Ribble Valley Borough Council
Council Offices
Church Walk,
Clitheroe
Lancashire
BB7 2RA

Phone: 0300 123 6780
Email: developeras@lancashire.gov.uk
Your ref: 3/2025/0038
Our ref: 3/2025/0038/HDC/KW
Date: 30 September 2025

Location: Units 3 3A 4 and 4A Cheetall Farm Clitheroe Road Bashall Eaves BB7 3LH
Proposal: Proposed demolition of single-storey rear and side extensions and conversion of barn to two dwellings with associated curtilage and parking areas.
Grid Ref: 371958 441992

Job/Scheme Number		Drawing Number	
0755/93		Drawing No 01A	
Scale	Date	Drawn	Checked
1 / 2500	Sept24	a.t.l-h.

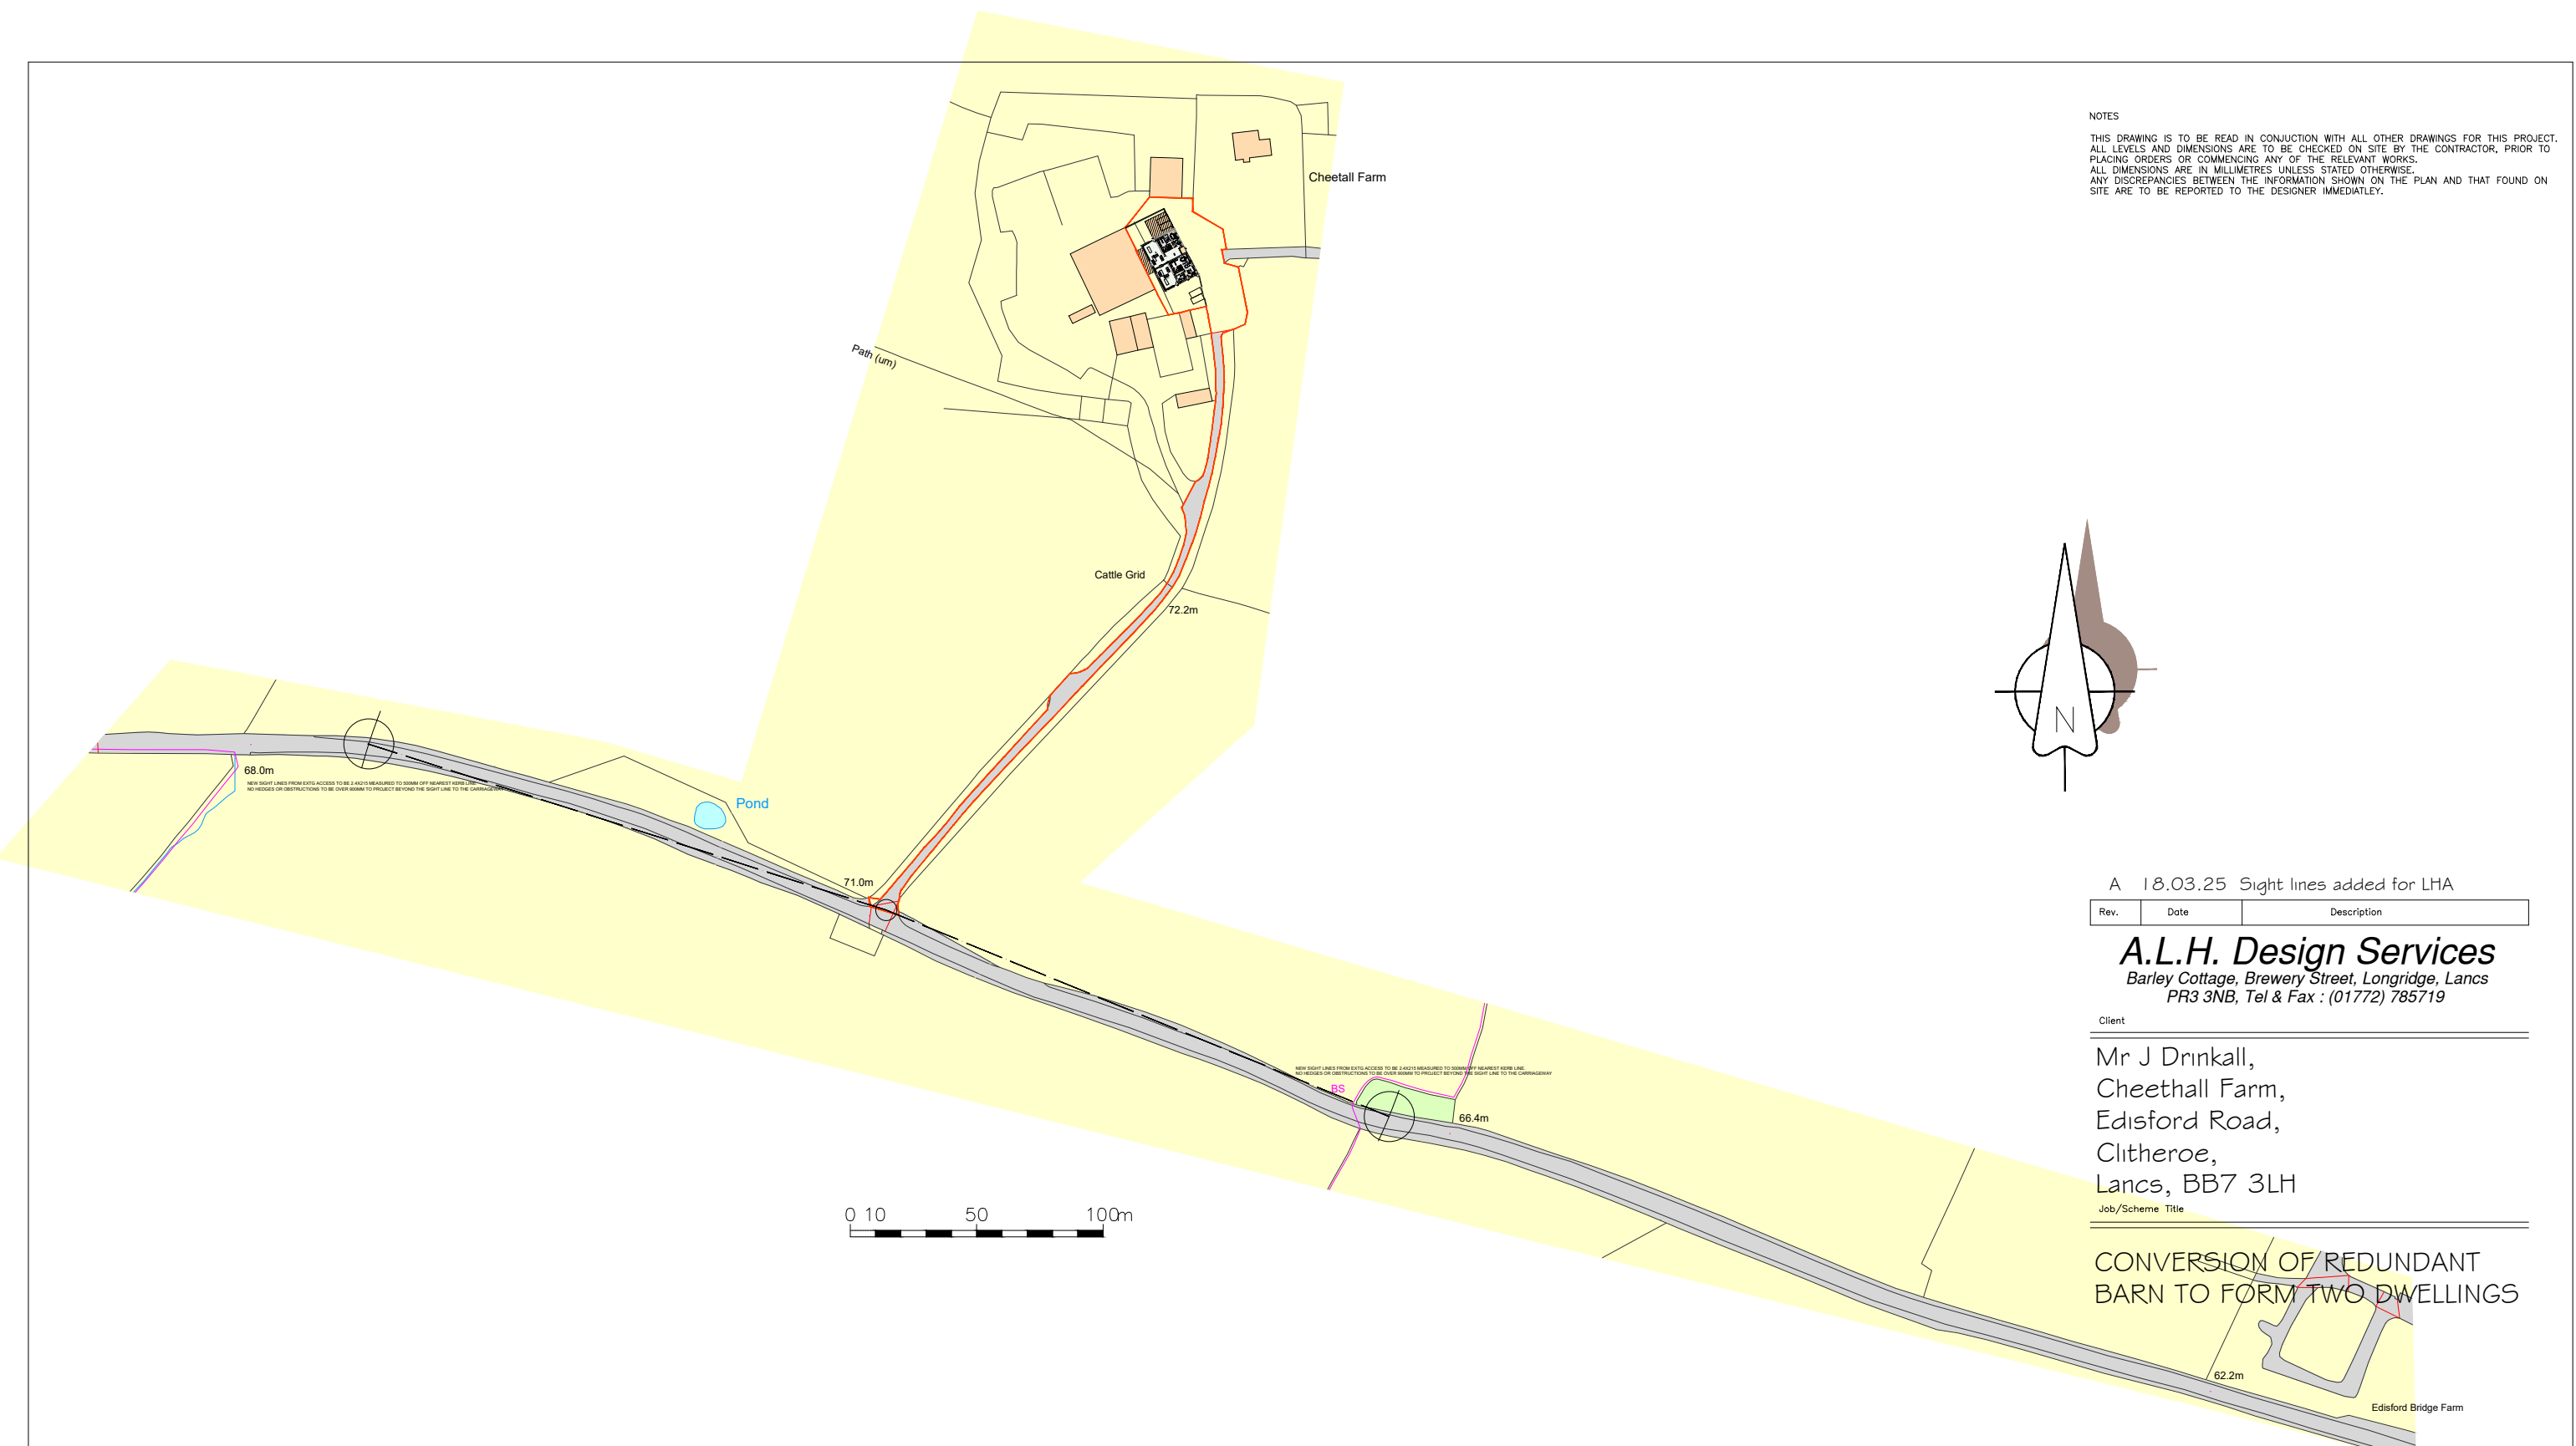
The applicant has also provided a visibility splay within drawing No 0 1A showing visibility splays at the existing access, which meets Clitheroe Road. No vegetation, walls or fences

which fall within the visibility splay shall be above 0.9m above the carriageway level to ensure intervisibility between the access and Clitheroe Road.

4. No use hereby permitted shall commence until visibility splays 2.4 metres back from the centre line of the access and extending 215 metres on the nearside carriageway edge in both directions have been provided at the access on Clitheroe Road, as shown on the approved plans. Nothing shall be erected, retained, planted and / or allowed to grow at or above a height of 0.9 metres above the nearside carriageway level, which would obstruct the visibility splay. The visibility splays shall be maintained free of obstruction at all times thereafter for the lifetime of the development.

Drawing Title
PROPOSED SITE PLAN

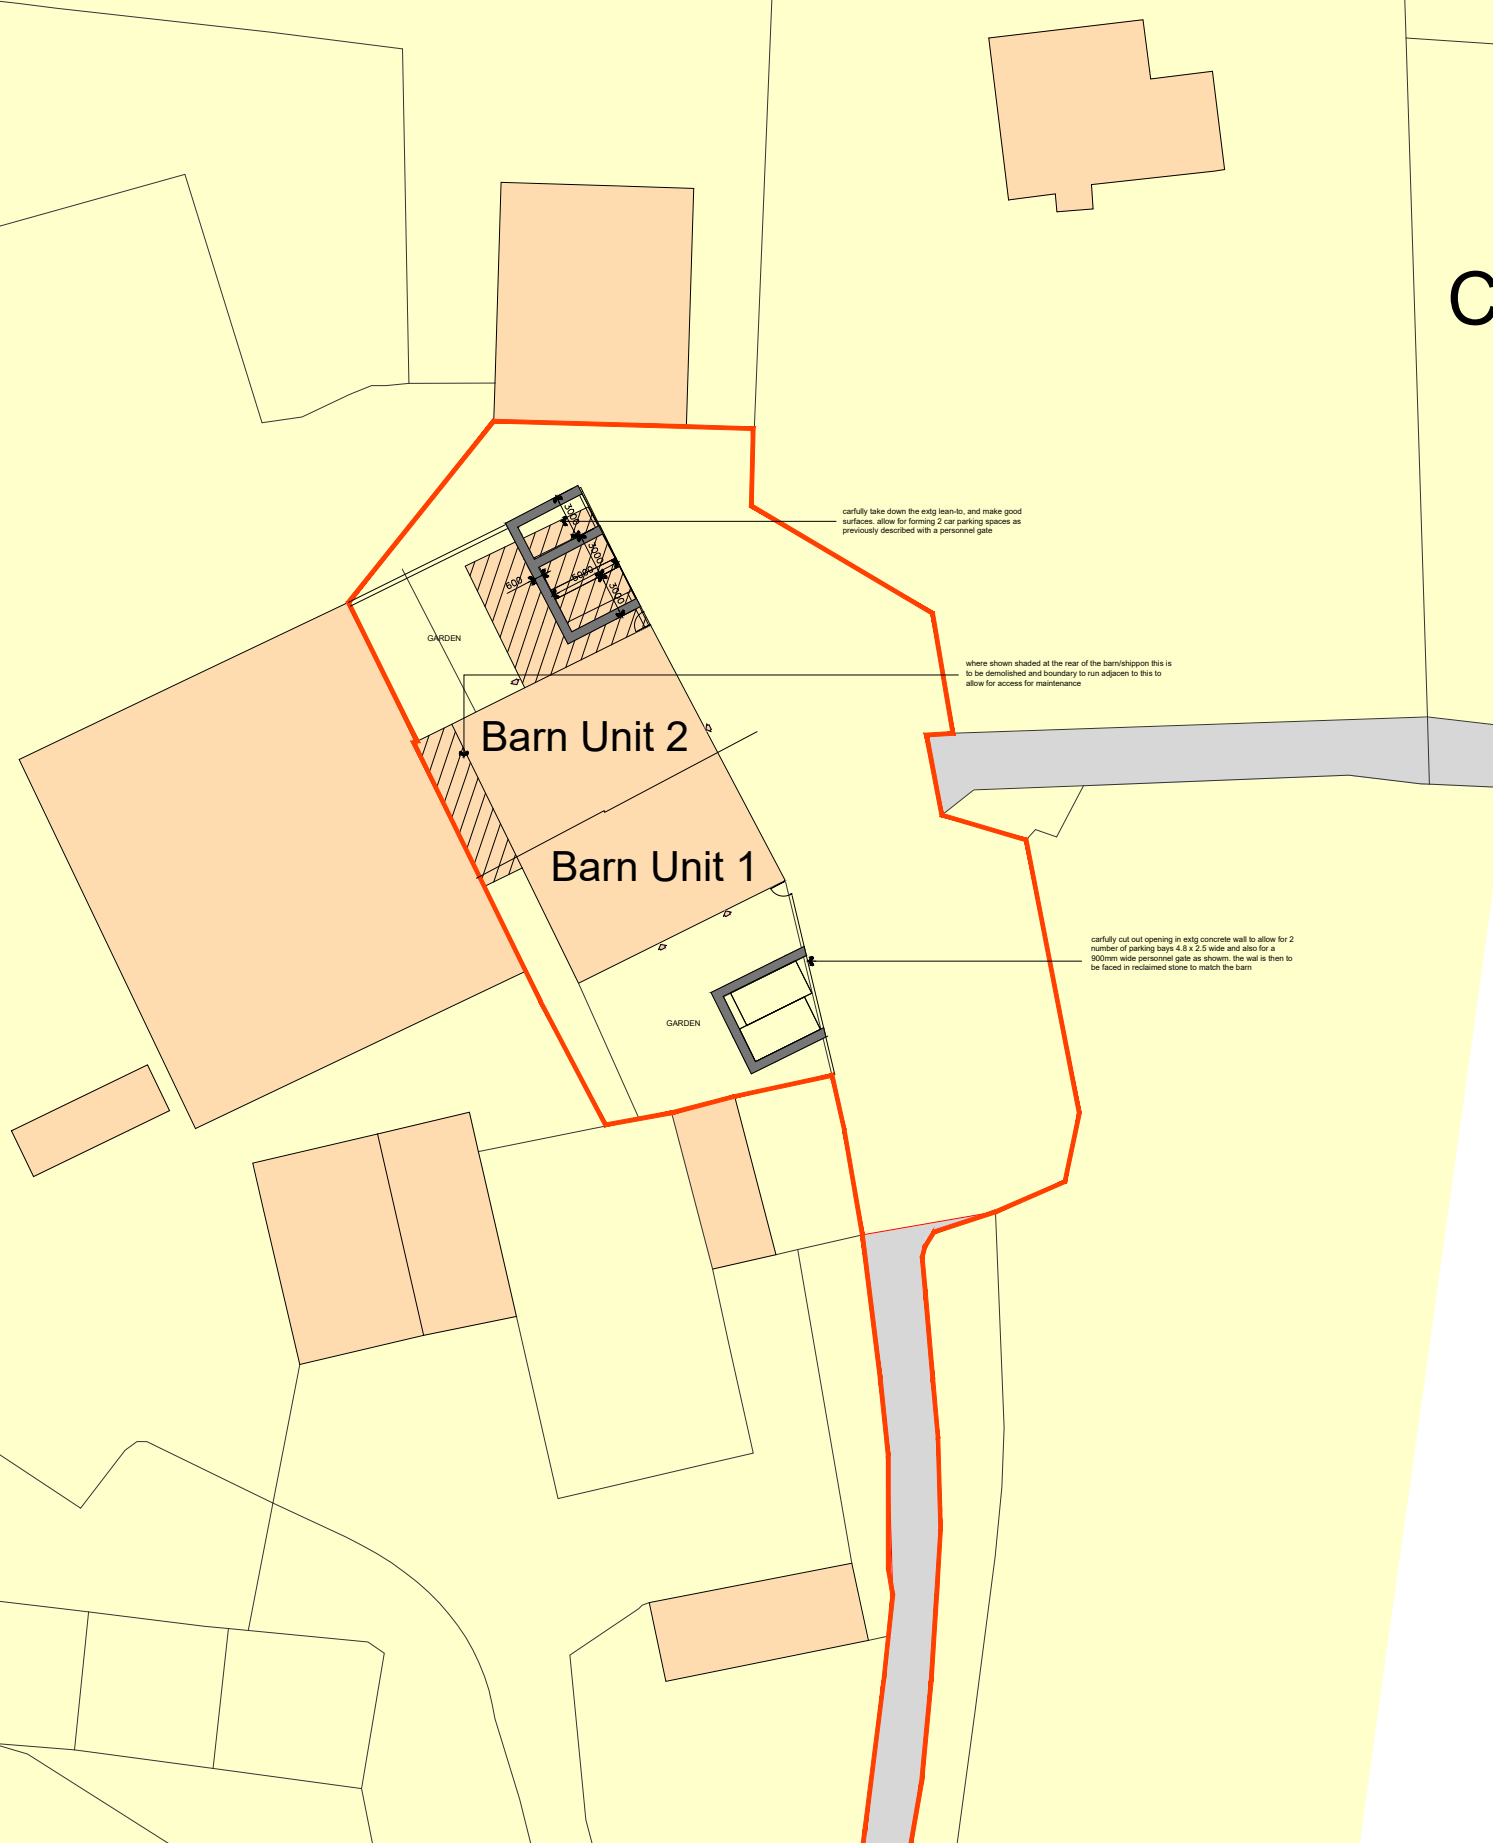
The LHA have reviewed drawing number No 0 8 B titled Proposed Site Plan and note 2 off street parking spaces will be provided for unit 1 and 3 parking spaces will be provided for unit 2 as such the parking provisions comply with the LHAs parking standards as defined in the Joint Lancashire Structure Plan

1. The development hereby permitted shall not be occupied or brought into use until the car parking and turning areas shown on the approved plan(s) have been provided in full and are available for use. The car parking and turning areas shall thereafter be kept available for the parking and manoeuvring of vehicles at all times.
